County File: OAR-20-018

Re: Cottages at Woodman Heights – Rezone, PUD Development Plan

To: City of Colorado Springs (Cynthia.Hurst@coloradosprings.gov)

PRELIMINARY  
 UTILITY & PUBLIC  
 FACILITY PLAN

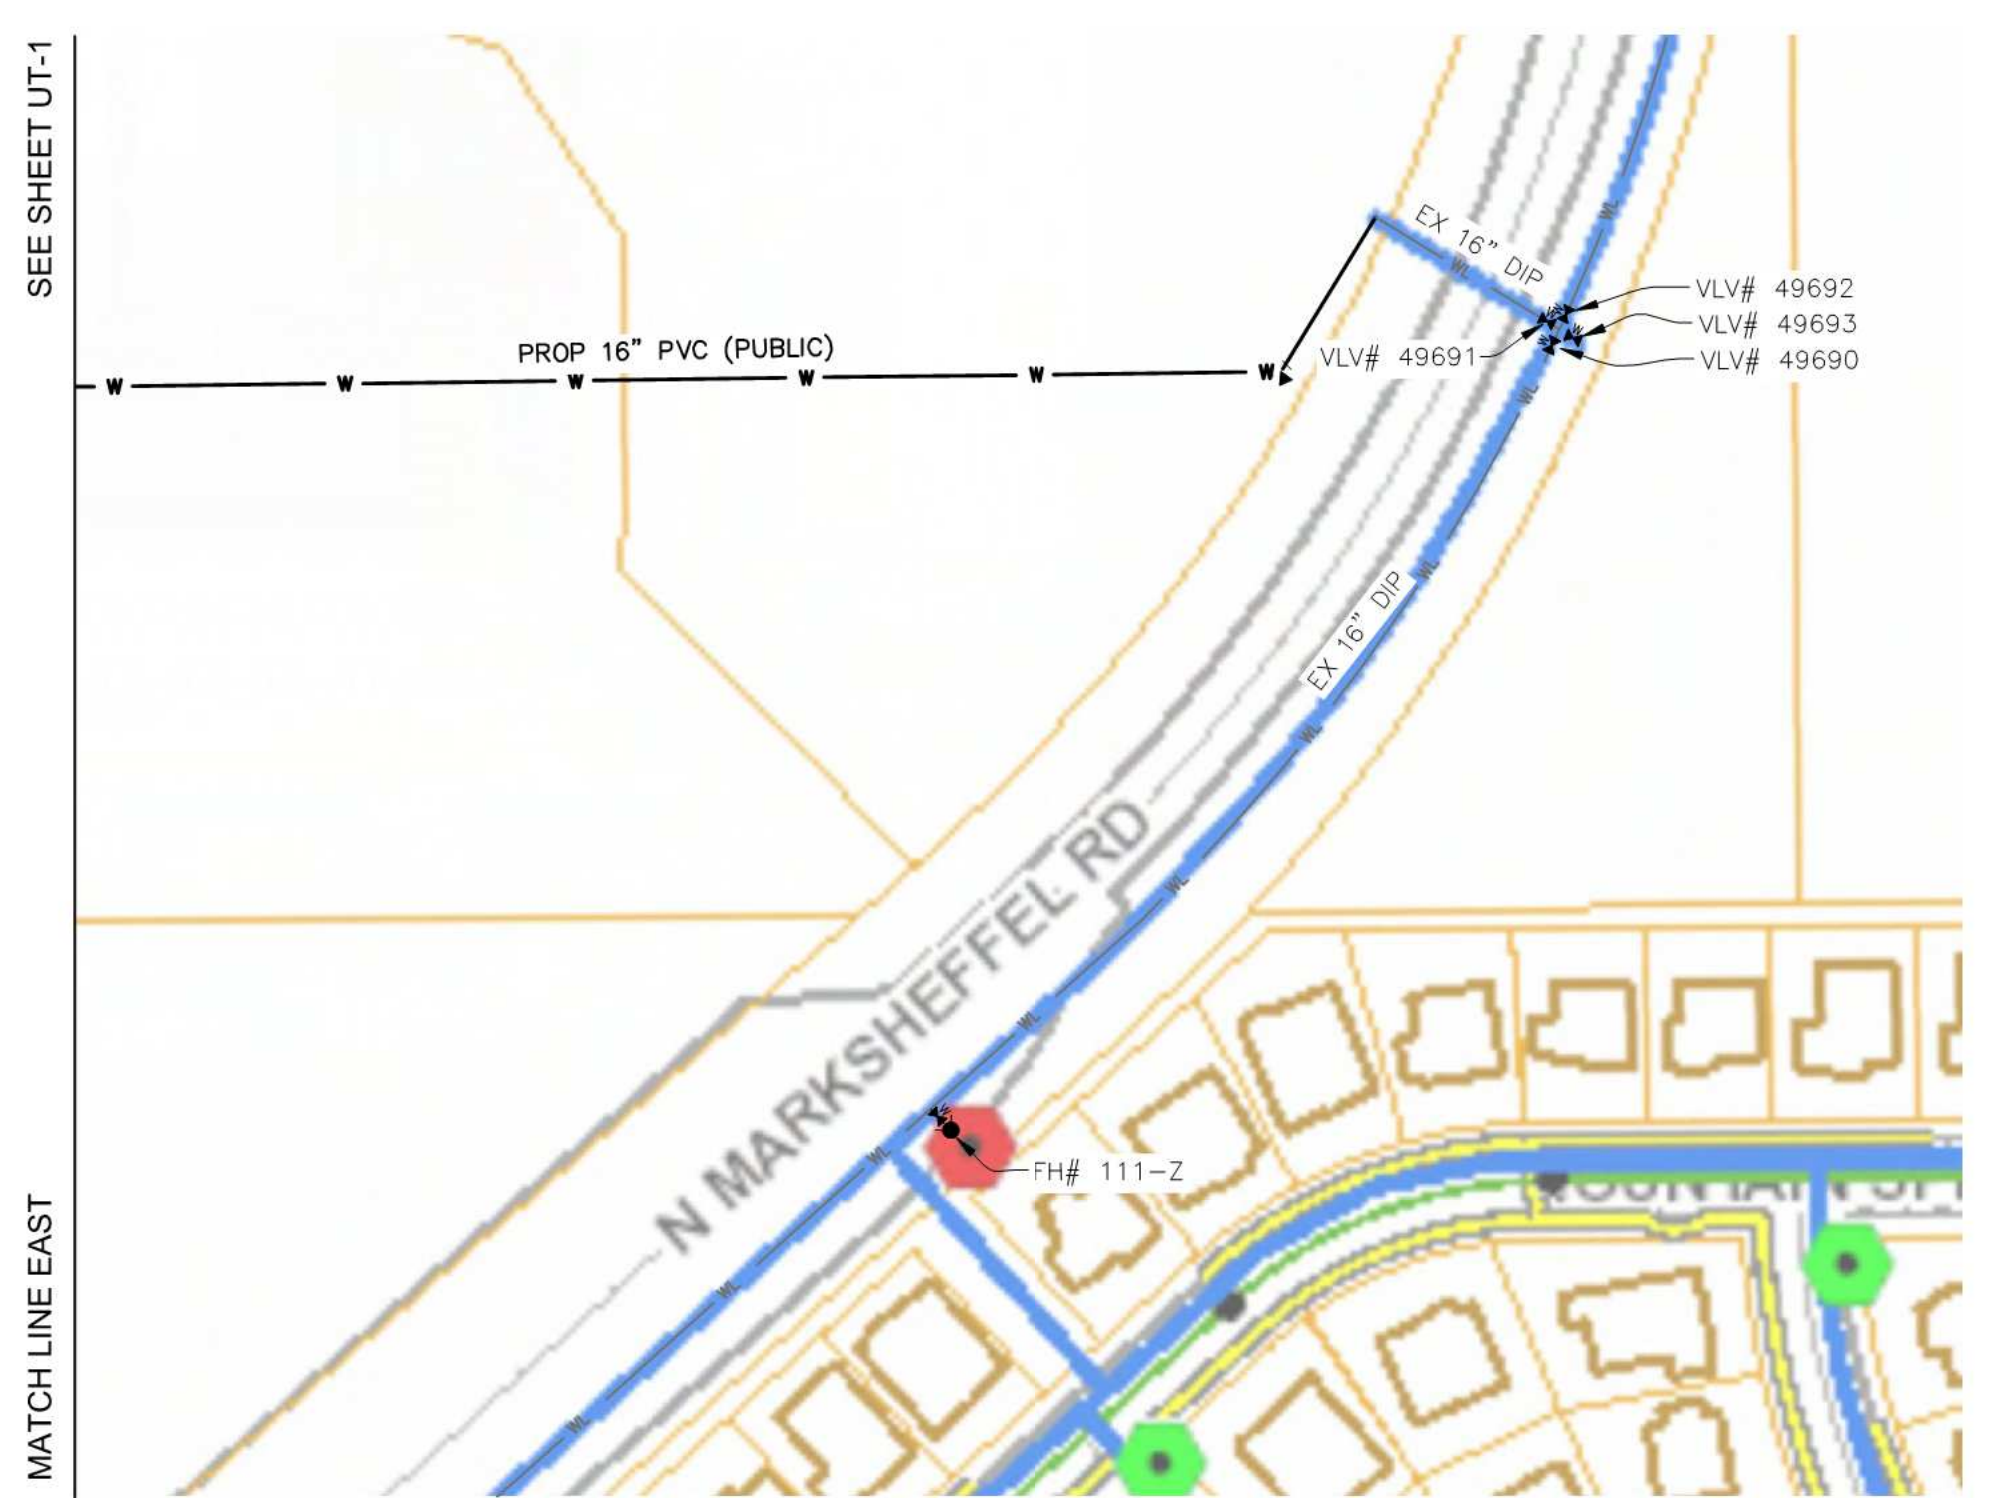
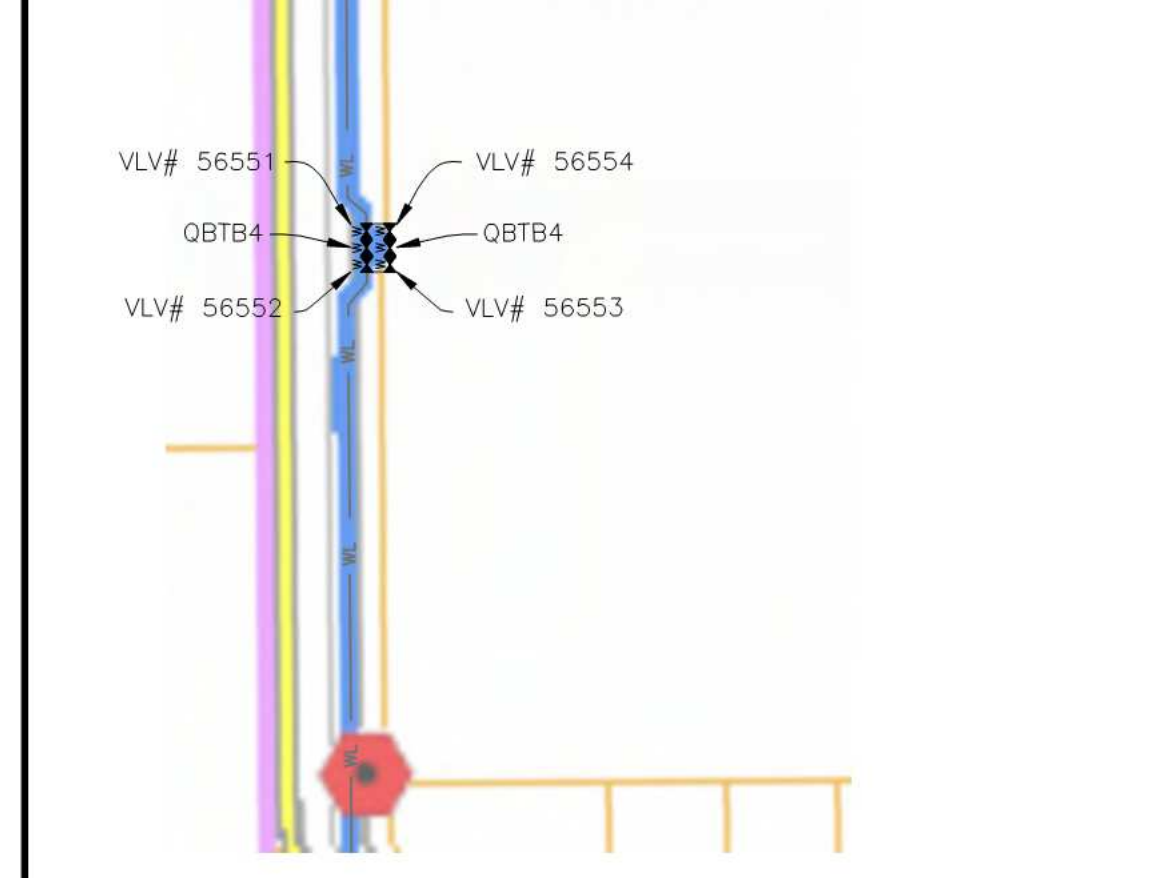
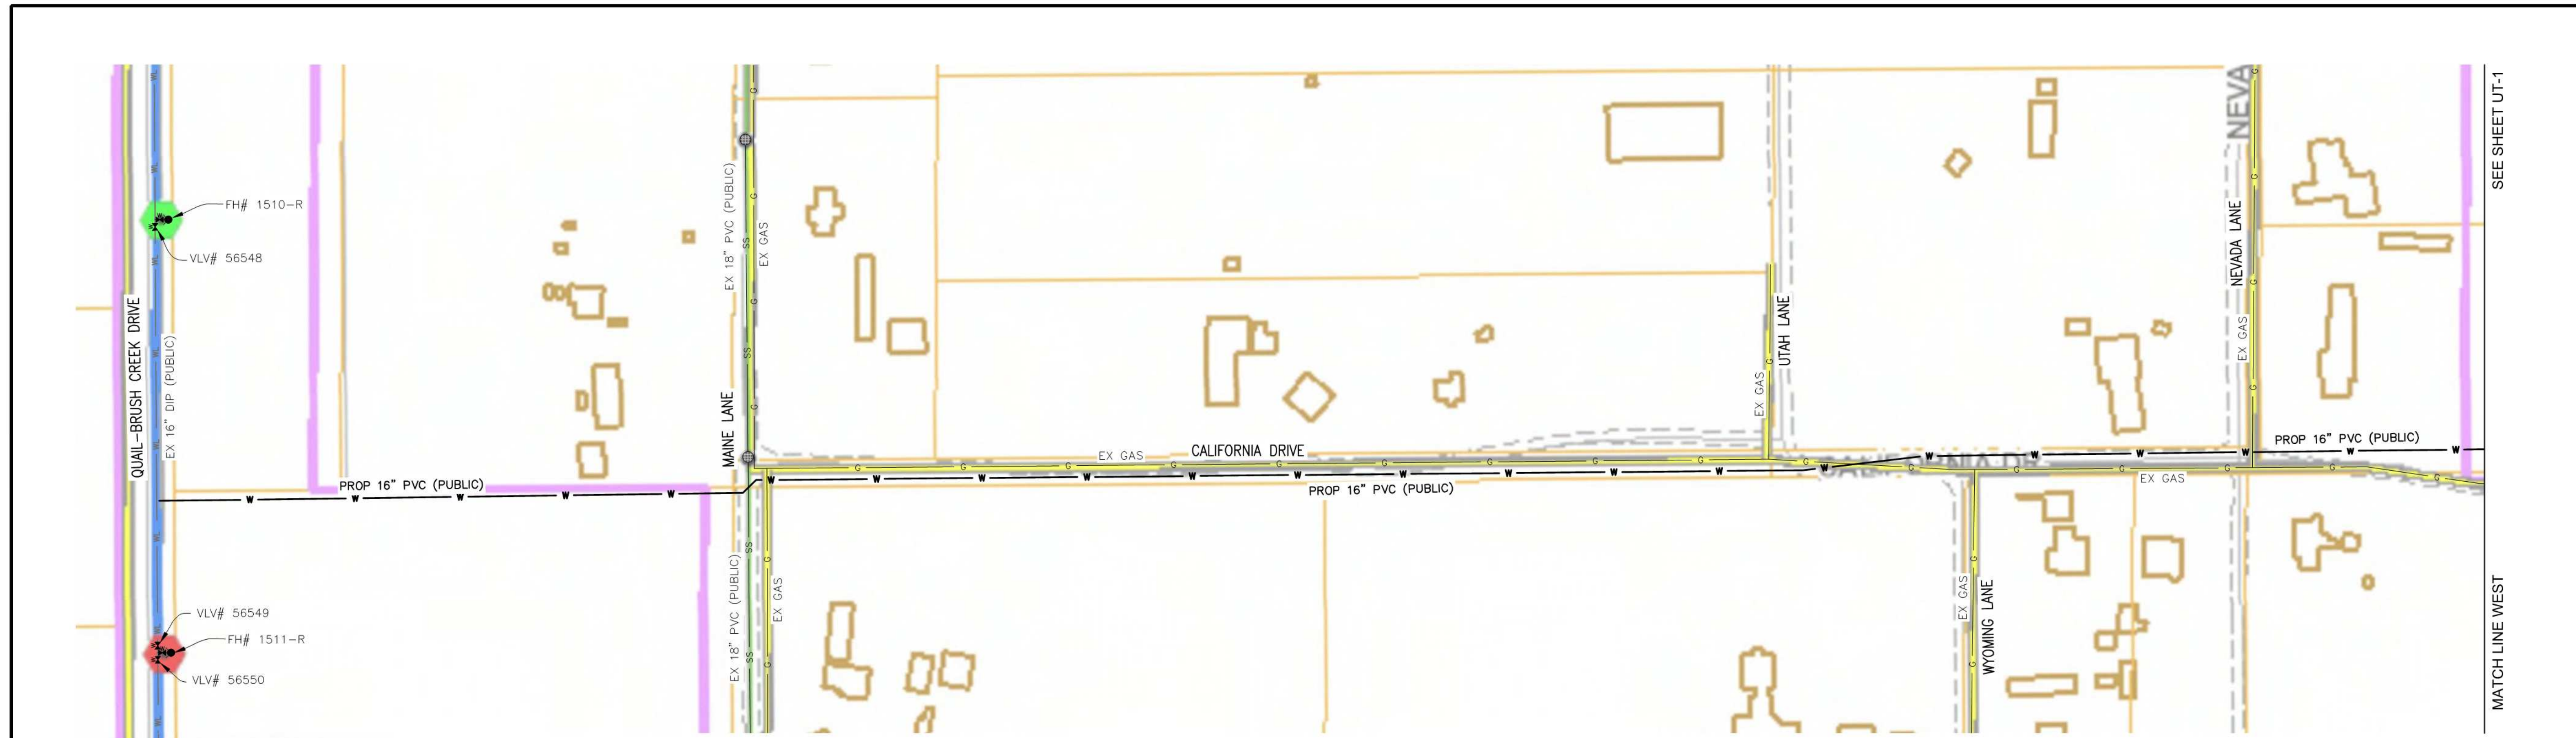
2. PCD-Engineering does not support the discharge of runoff from an area greater than the historic contributing acreage (17.5 Ac. onsite) to the proposed south detention basin outfall location that flows south to offsite properties. Even if the peak flows are mitigated, developed base flows and volumes have the potential to negatively impact the downstream channel and properties. However; if the

downstream property owners grant drainage easements as appropriate this may be acceptable.
